Highways Development Management
Planning Application Consultation Response

Planning application number: 22/01030/FUL

Description of development: Works to improve the quality of parking provision. Relocation of most parking from the Hall entry area, provision of all-weather parking in the south-west part of The Paddock, improvements to parking surface in the Lower Walled Garden and associated hard and soft landscaping works in the areas around the Hall entry.

Location: English Heritage Belsay Hall Drive Belsay Northumberland NE20 0DX

Title  
**Estate Entrance Works**

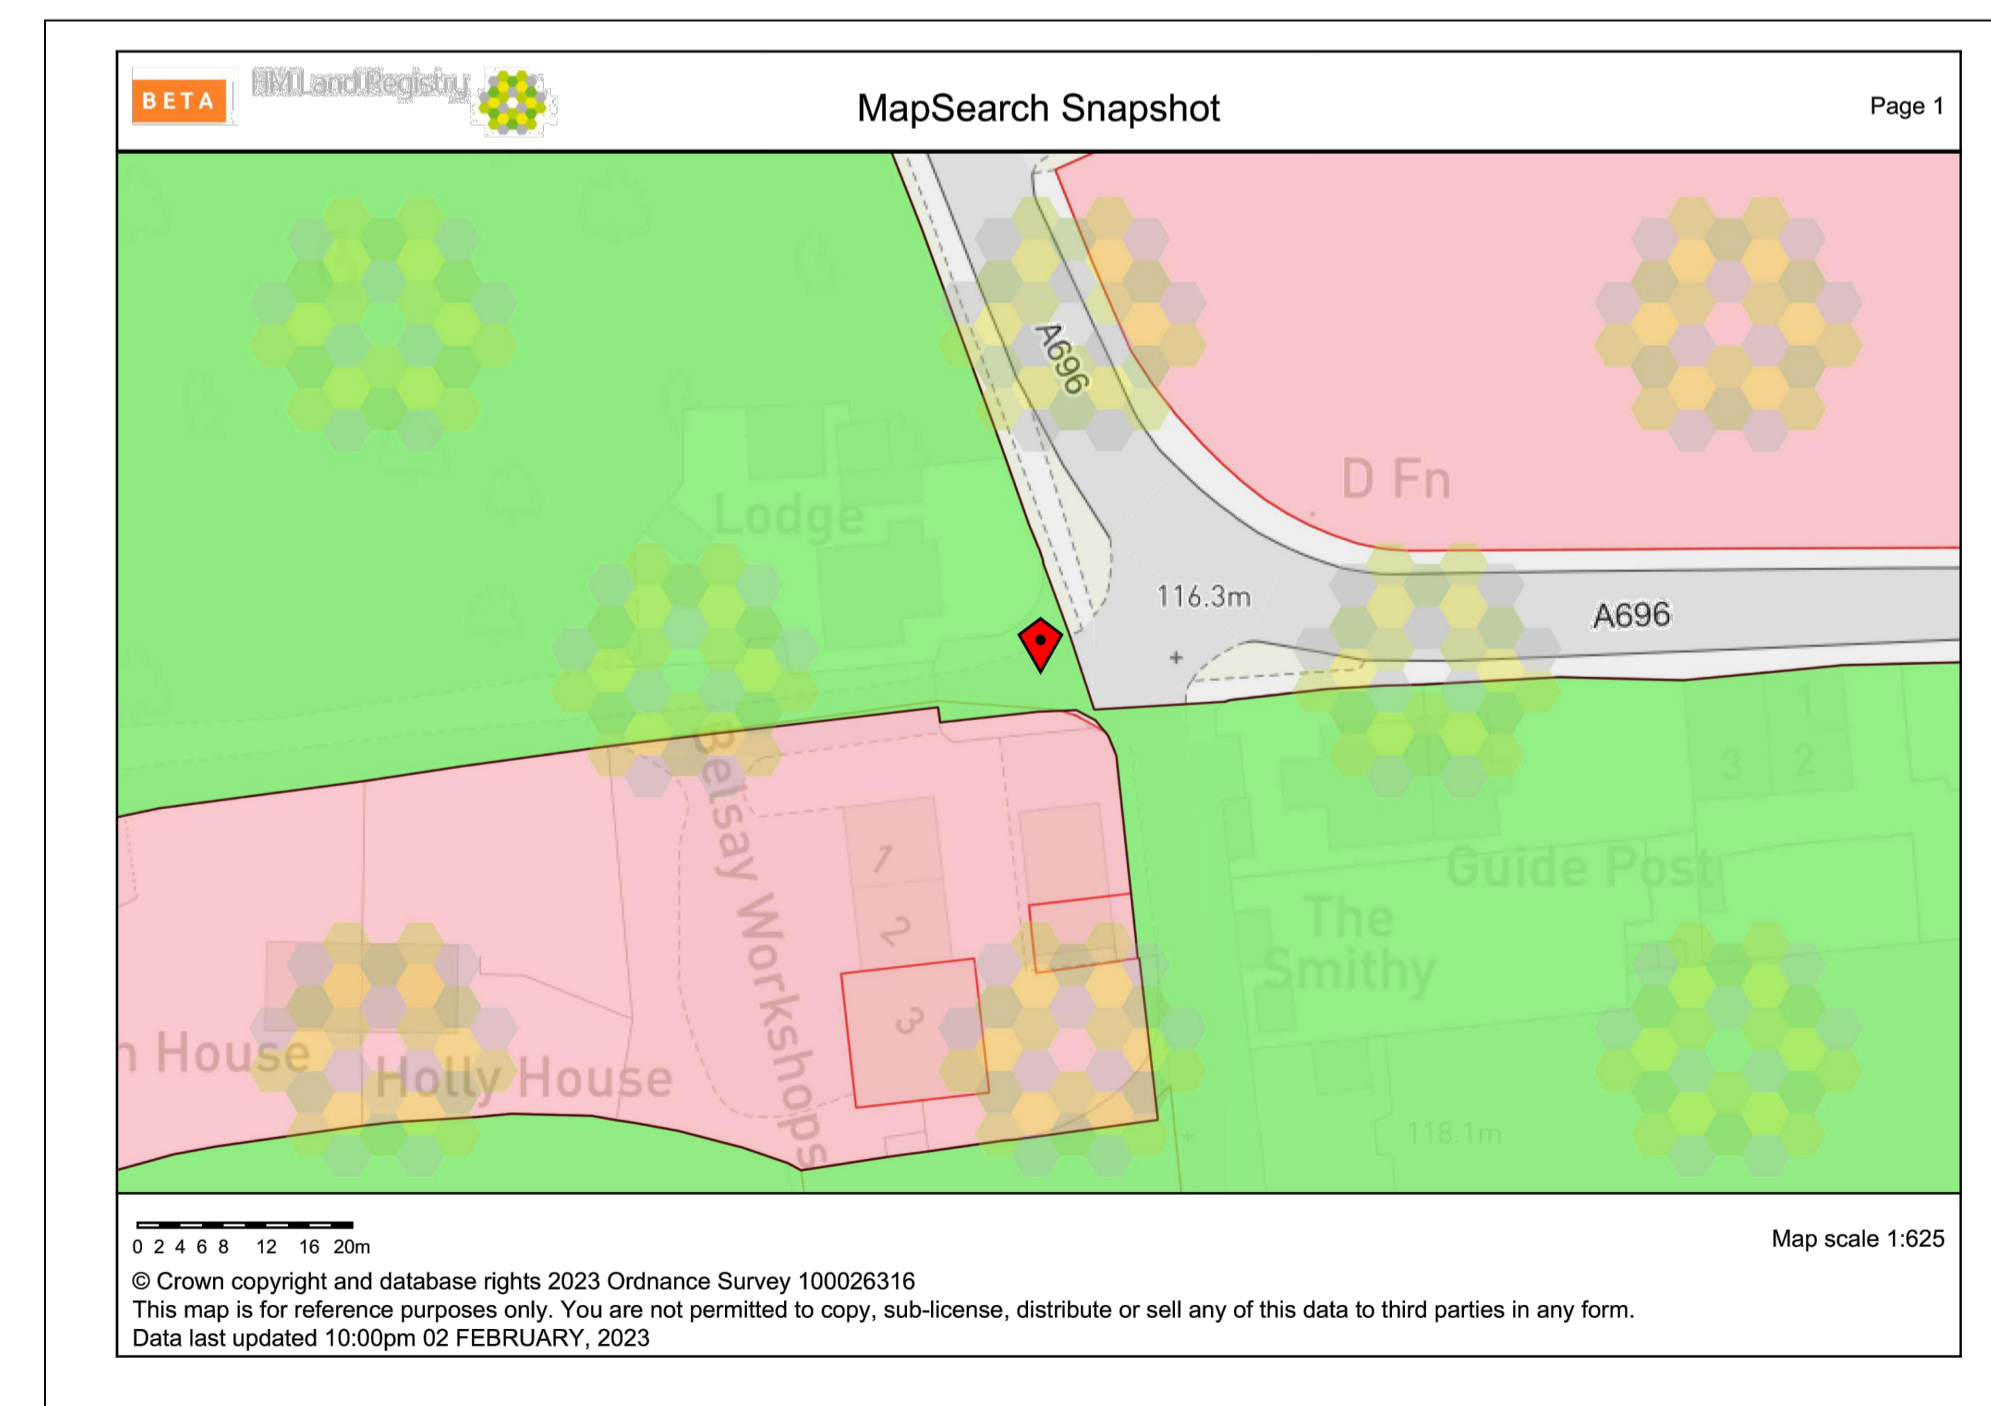
It is noted that the tourist attraction expects to generate 69,853 visitors within the 2021/22 season which is in keeping with the 2018/19 season prior to the Covid-19 pandemic. Considering the substantial amounts of visitors and their associated trips generated per month which has occurred over many years, the junction has become worn and is breaking away in some sections. The applicant is required to repair and resurface the junction in accordance with NCC Type C specifications.

The applicant has been requested to repair and resurface the main junction onto the A696 due to excessive wear over the years of visitors coming to the site. The applicant will need to enter into a Section 184 agreement with the Local Area Highways Office and a condition will be requested that will enable the applicant to present an extent and constructional drawing of the works.
